Martin Nugent
01254 828060
D3/11/0675

Drafted 4 October 2011

**Planning Application, Ribbles Valley District
3/11/0675 Aspinalls Farm, Kenyon Lane, Dinckley**

Amendment D: 25.10.11 further to highway engineer request include two passing places. Submit plans to LPA for approval.
PLANNING DRAWINGS - existing & proposed site plans & proposed location plan

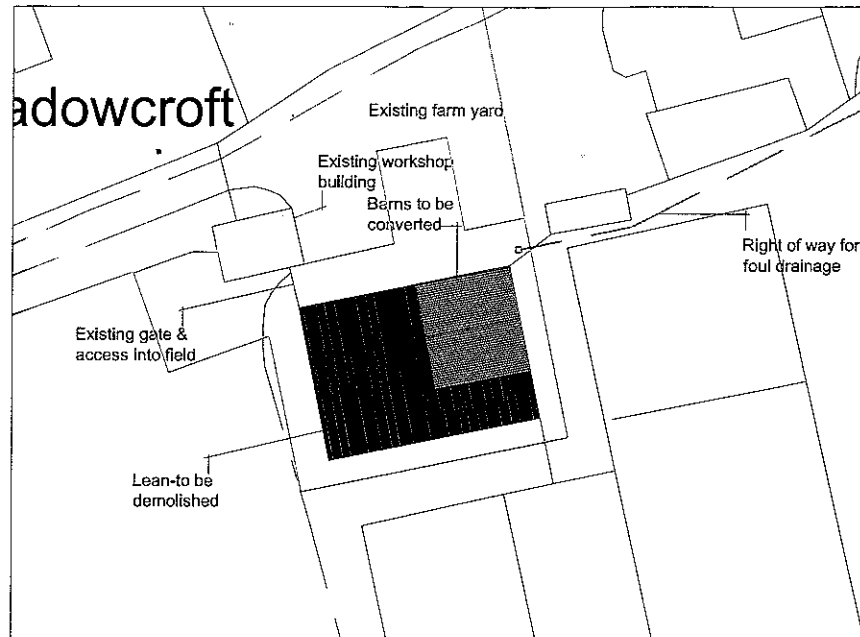
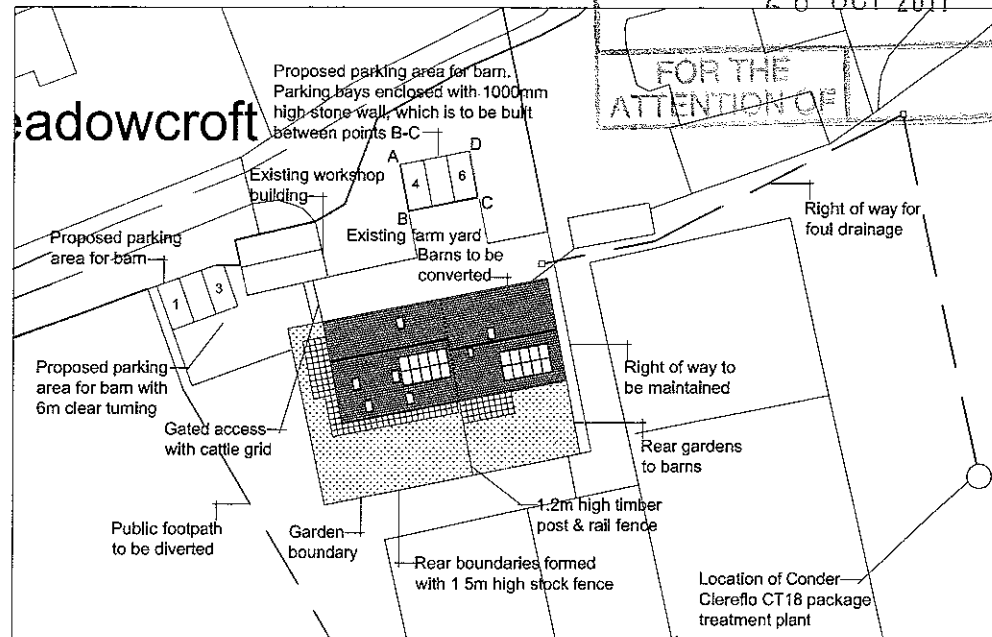
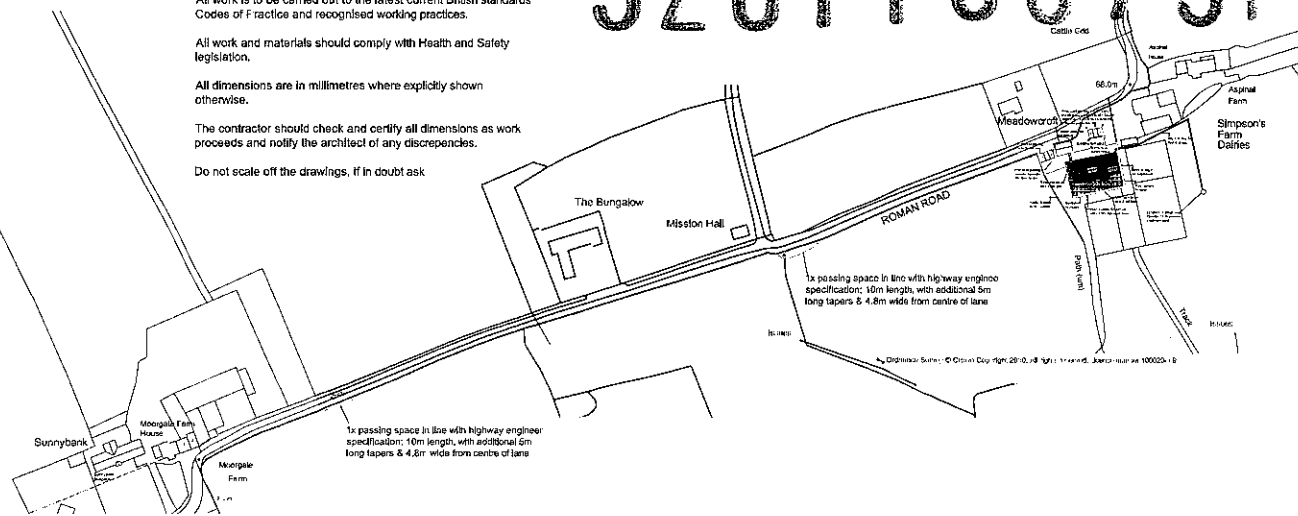
The site plan identifies two locations where parking is provided for three vehicles. I am satisfied that this level of provision is adequate for the operation of the proposed residential properties and that the location of the bays has a neutral impact on the safe movement of agricultural vehicles.

On the site plan submitted, the red edge identifies the proposed areas of residential development. This includes the parking bays and the relevant areas for manoeuvring to and from these spaces. I would recommend that the proposed wall for the three parking spaces within the yard is repositioned. With the wall placed to the property side of the bay, there is less likelihood of other vehicles parking along the "open" of the bay and potentially obstructing passing vehicles.

The design of the bay within the yard and to the north of the proposed residential development should be the subject of an amended site plan, with the layout to be agreed prior to consent being granted. If this is not secured, then a further condition would be required.

Finally, the function of the access track serving the existing agricultural sites and residential properties on Moorgate Lane, as it continues from Kenyon Lane, requires the provision of two suitably located and constructed passing places. There was a

1. That no materials or vehicles are stored within the farm yard, north from the red edge shown on the site plan, Drawing for Project No.SIM/477/1208/RO1 (dated 17 August 2011), to Moorgate Lane.
2. That two passing places be introduced on Moorgate Lane, between Aspinalls Farm and Moorgate Farm, to be of minimum dimensions, length 10m, incorporating 5m tapers and of width 4.8m from the centre of the lane.
